Our ref: TR010022/S51 Response

1 July 2019

**A38 DERBY JUNCTIONS
PLANNING ACT 2008 SECTION 51: NOTIFYING PERSONS OF ACCEPTED
APPLICATION**

I am writing regarding the proposed A38 Derby Junctions scheme and your letters dated 21 May 2019 and 22 May 2019. Please see below the response of Highways England to the issues raised.

Drawing file: published-documents / TR010022-000477-TR010022_A38_6.2_Environmental_Statement_Figures_Figure_5.3A-C.pdf

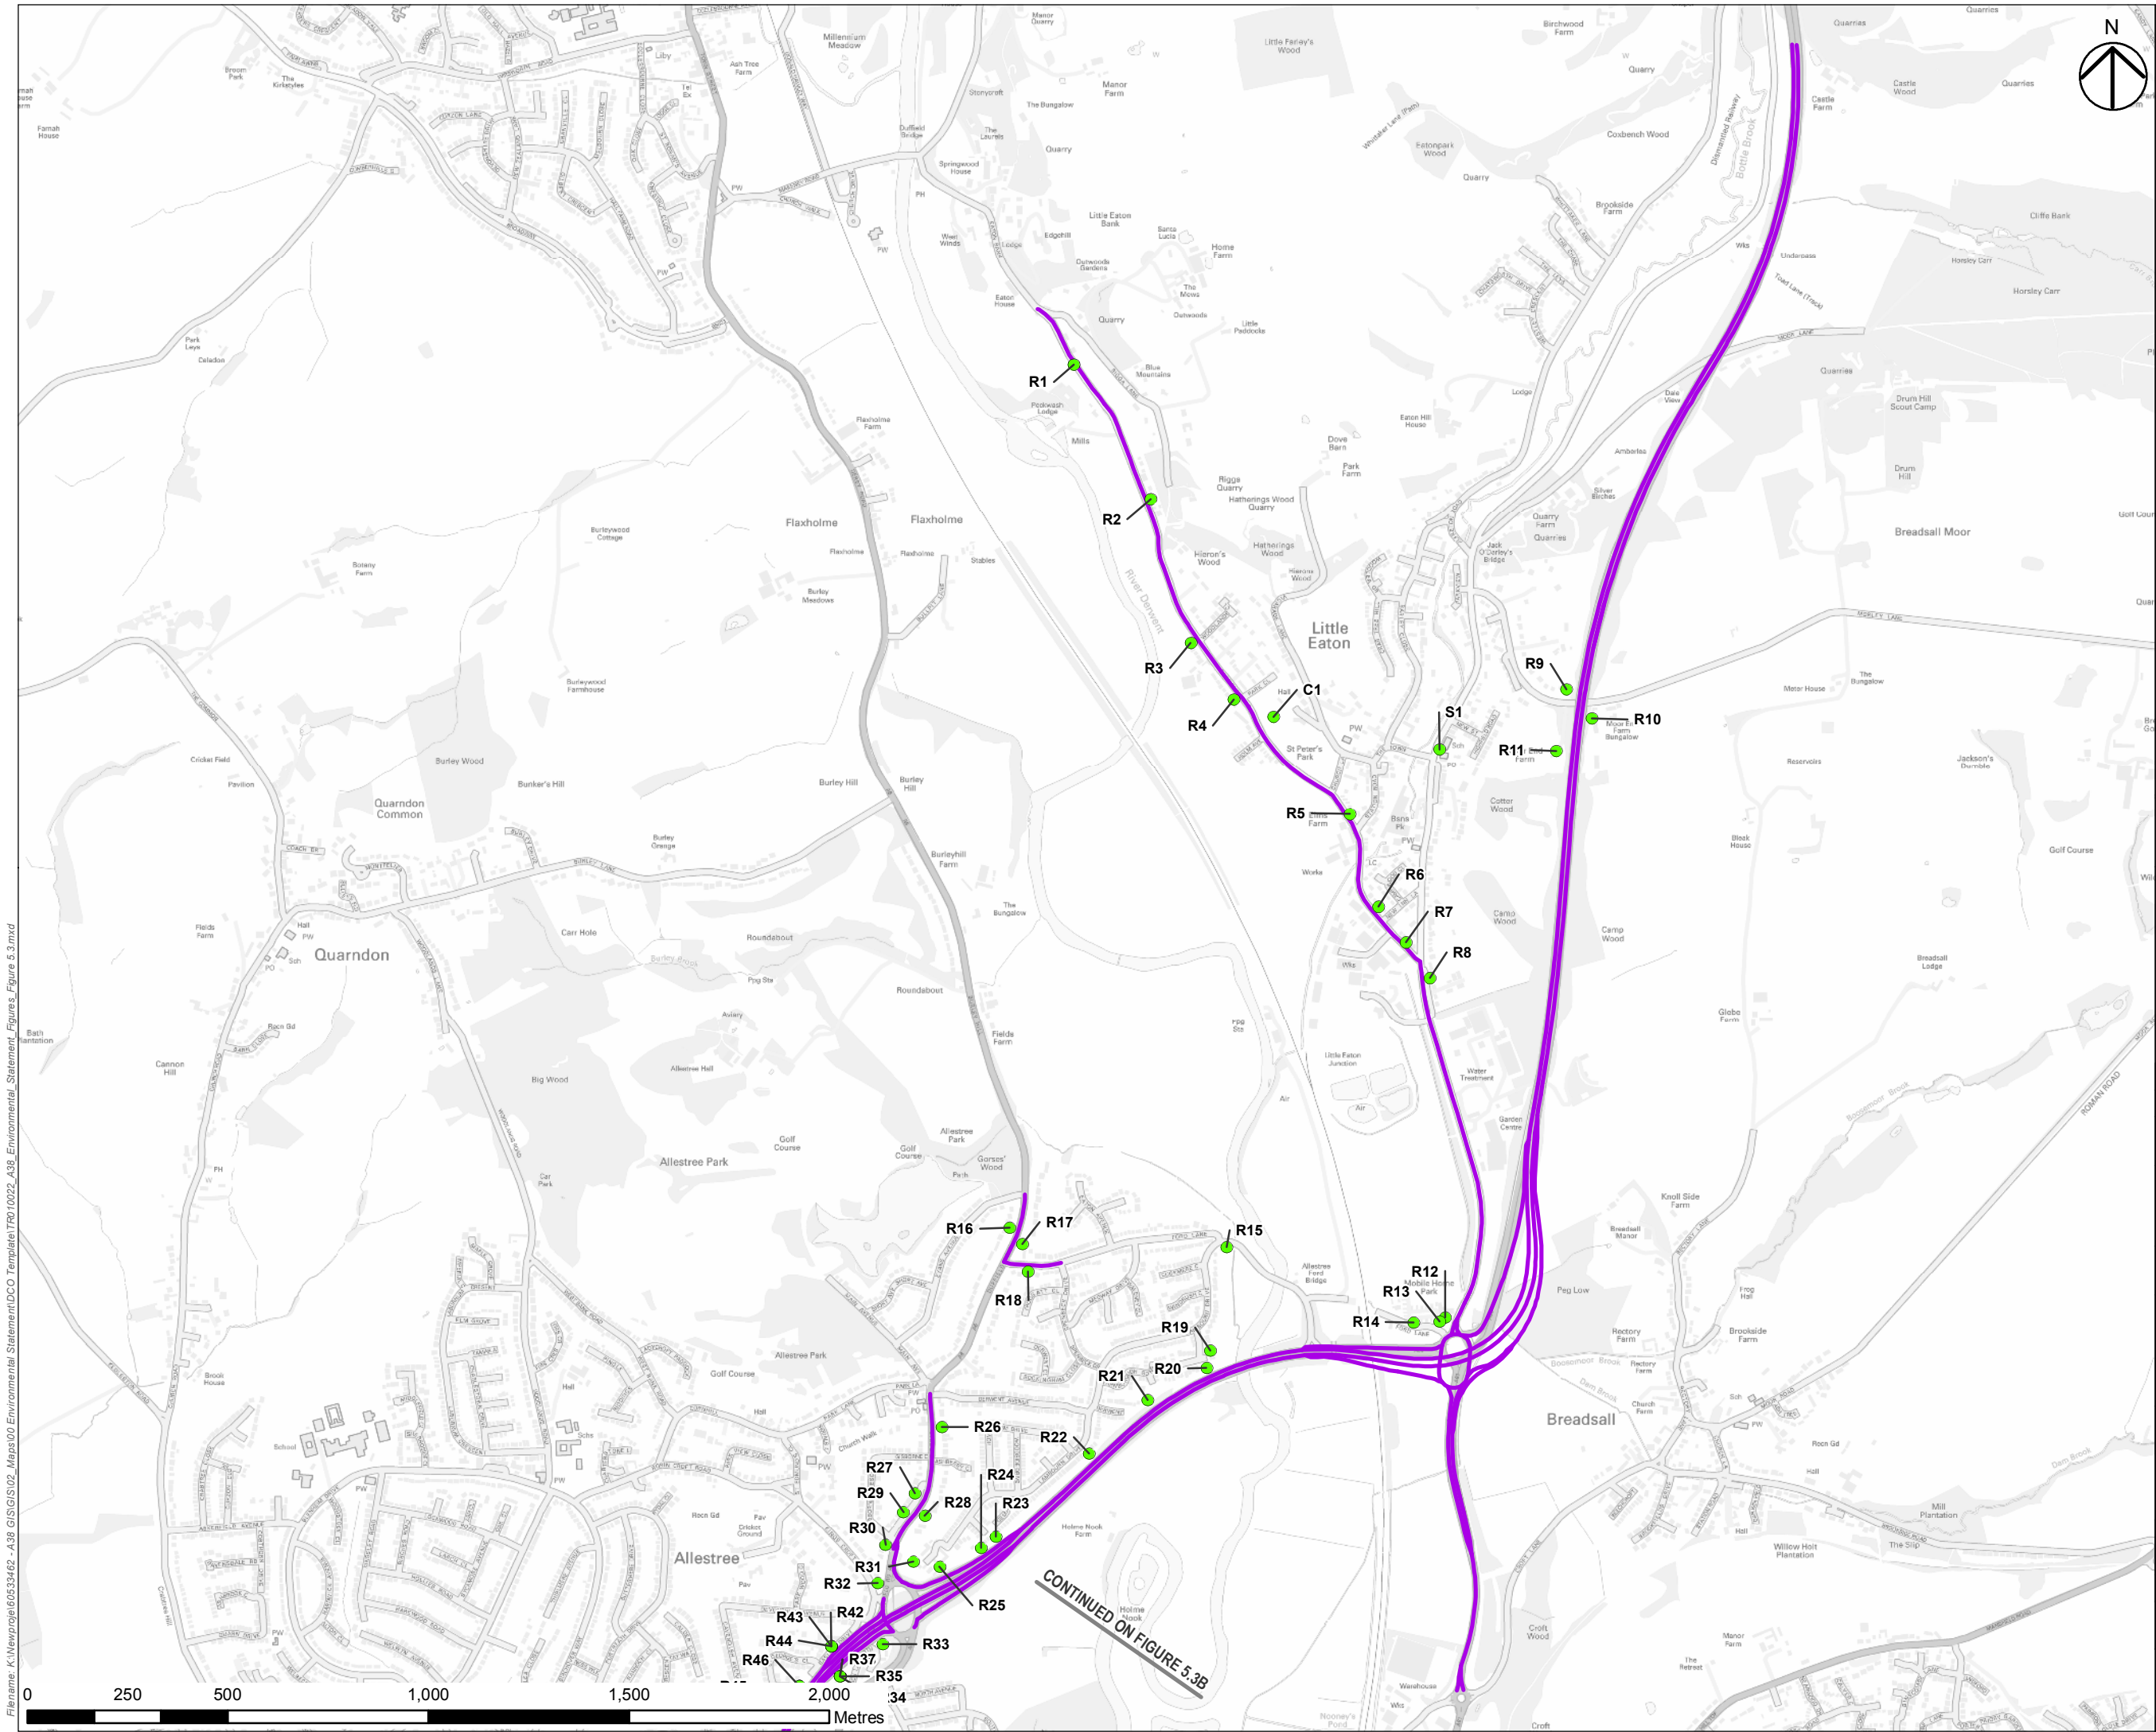
ES chapter 5, paragraph 5.6.2 states that the assessment of “operational phase traffic effects uses a study area of 200m around roads likely to be affected by the Scheme” and ES paragraph 5.6.3 sets out standard screening criteria used to determine study areas. Figures 5.2a-c and 5.3a-c set out the receptors considered in the construction phase and the opening year of operation. However, no detailed information is provided to explain how the selected receptors were derived with reference to the 200m study area and screening criteria thresholds. Please provide further detail regarding the findings of the receptor screening process set out in the ES.

The ARN for the Scheme opening year is presented in ES Figures 5.3 A-C. A similar exercise was undertaken to identify the ARN for the construction scenarios. The construction scenarios assessed are explained in ES para 5.5.6 - 5.5.7 and 5.8.8 – 5.8.9. The identification of the ARN is explained in ES Para 5.6.3 – 5.6.4. Additional figures have been produced (Figures 5 - 10, also enclosed with this response). These figures illustrate which road links are affected during the construction scenarios by changes in traffic flow or HDV flow, with the three construction scenarios assessed. The road links meeting the qualifying traffic screening criteria during any of the construction scenario were included in the ARN for construction impacts. The construction phase ARN is shown on ES Figures 5.2 A-C. The additional figures produced are:
